**WEST SUSSEX COUNTY COUNCIL
INFRASTRUCTURE CONSULTATION**

SUBJECT: FP/196/09 - Continuance of use without compliance with condition no's 3, 4, 5, 6, 7, 9 & 11 imposed under planning reference FP/49/09

Sea Lodge, Sea Bank & Sea Grit, Outram Road, Felpham, PO22 7AL

Figure 2 – Proposed Site Layout

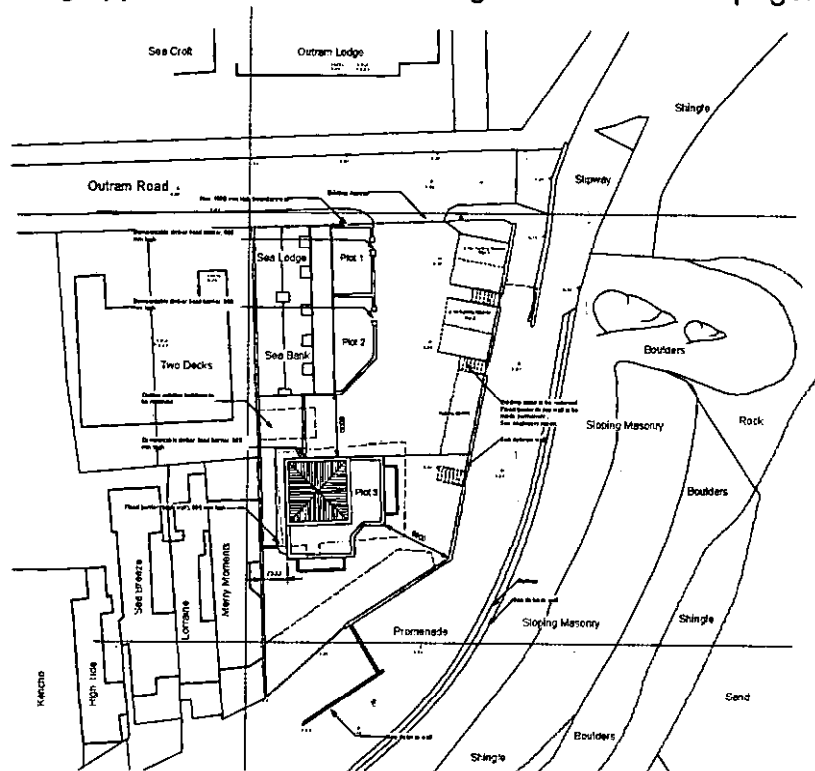
The apparent proposed variation of condition 7 would require only cycle parking to be provided for plot 3. Plot 3 is in effect the only new dwelling. Presumably, as plots 1 and 2 are existing dwellings and may already have cycle parking, the proposed variation of the condition therefore seeks only to secure cycle parking for the new dwelling only. If this is the case, then there would be no objection to the variation/non compliance of the condition. However, it is unclear, and there would otherwise seem no reason why cycle parking as per the original condition could not be secured.

With regards to condition 9, the existing dwellings already have existing parking areas, thus in reality only parking for the new dwelling would need to be detailed. There would be no objection to the variation/non compliance of this condition.
